RE: 549-553 Cumberland Avenue, (called 553) – 048-E-027 – (the "Property") - R-6
Zone

I am in receipt of your request for a determination letter concerning the Property.

Permit No: 09-0651	Issue Date:	CBL: 048 E027001
------------------------------	--------------------	----------------------------

Proposed Use: Commercial/Multi family - 27 dwelling units - upgrading interior egress components to best meet current codes	Proposed Project Description: Change of use from 28 to 27 dwelling units- upgrading interior egress components to best meet current codes
---	---

A-0.1 7/22/09
 REVISED 9/28/09

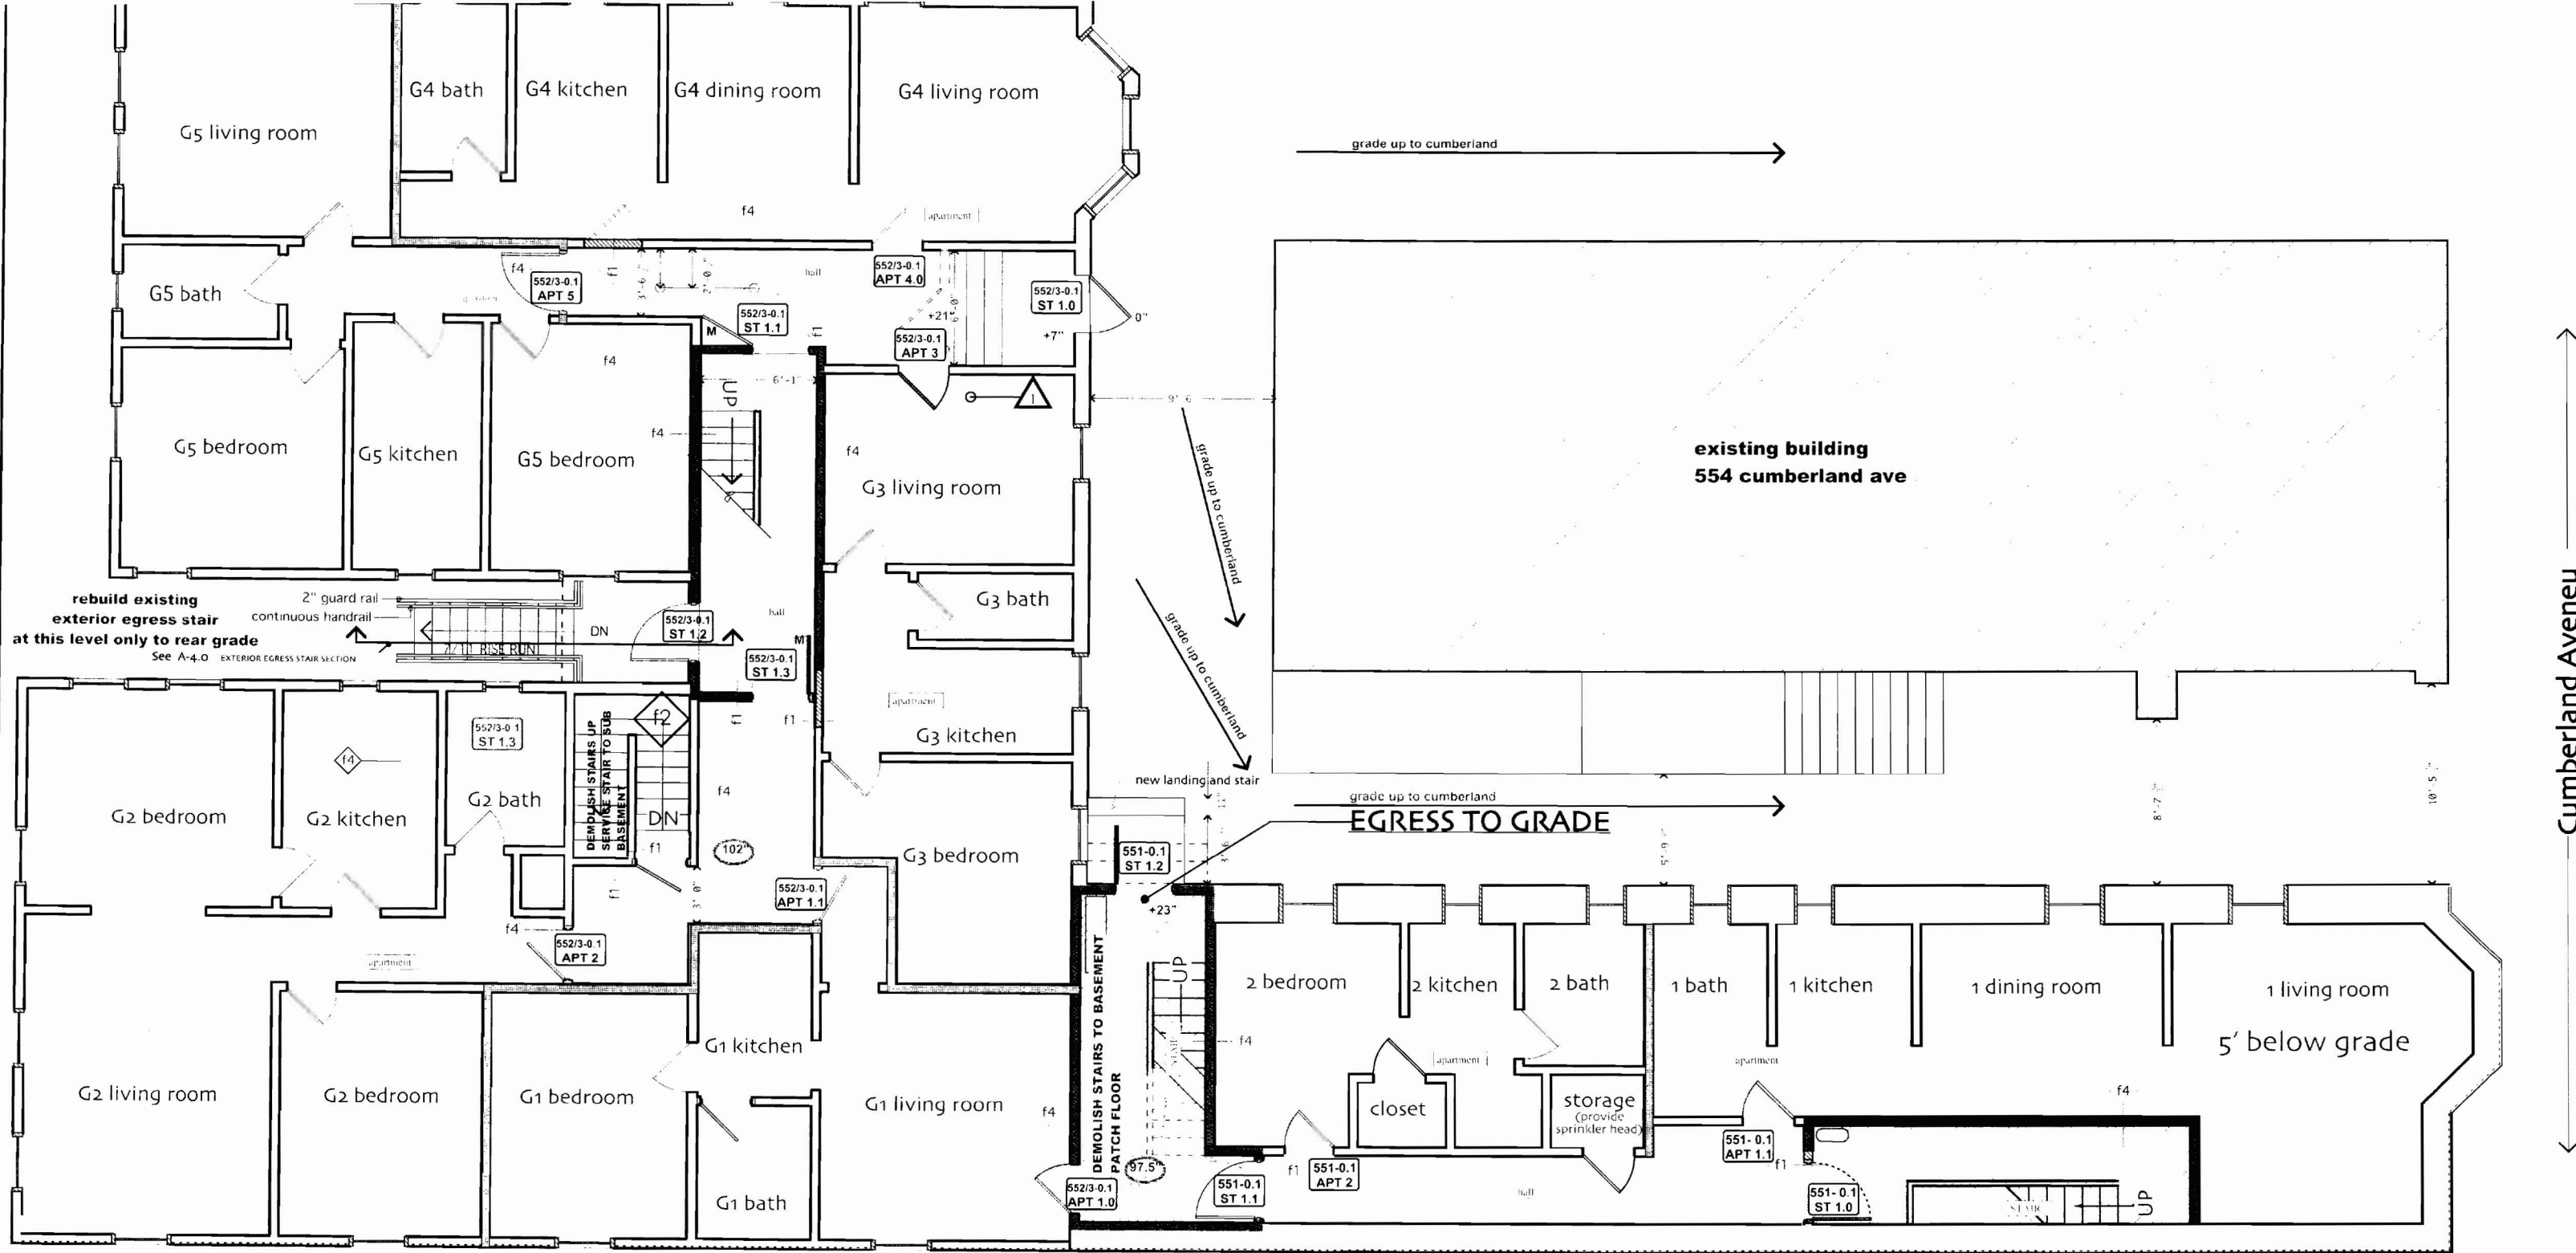
9/8/2009-jmb: Left vcmgs on 2 phones for Jim S. Who is on vacation until 9/14. Need clarification on closet door in common hall near 551-0.1 on plan A-0.1, and wall type addition of insulation, roof framing and stair landing detail, and where is F2.1. Also cost of work requires a design compliance.

9/11/2009-jmb: Jeremy Mosier called and reviewed the code questions, he will submit revisions by midweek.

10/1/2009-jmb: Received revisions from Jeremy M.
